Bowland with Leagram Parish Council

Re Planning Application No. 3/2014/0304

Leagram Lodge, Chipping
Single storey rear extension

Title **PROPOSED ELEVATIONS**

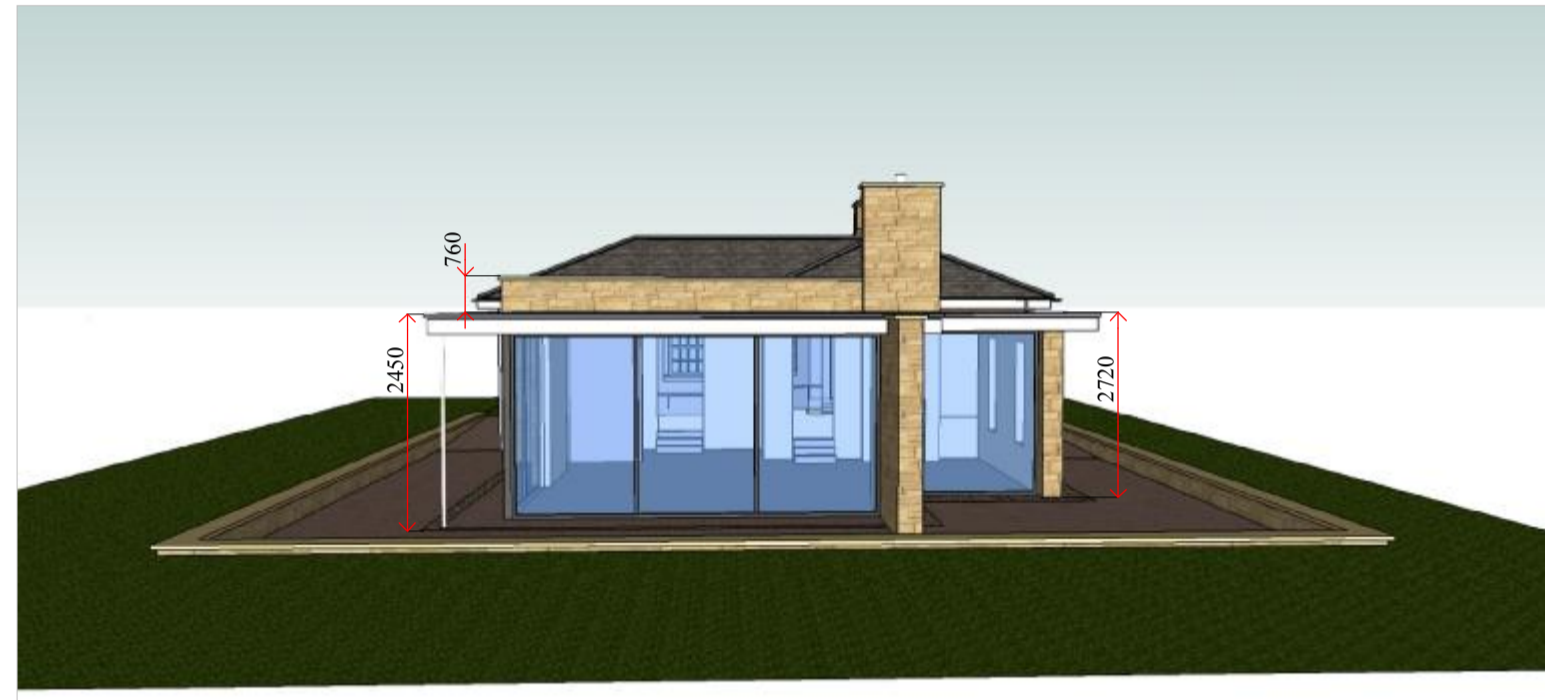
Further to your letter of 16th April, I am pleased to advise you that the Councillors have considered the above mentioned application. They feel that the design of the proposed extension is not in keeping with the existing building, particularly the flat roof.
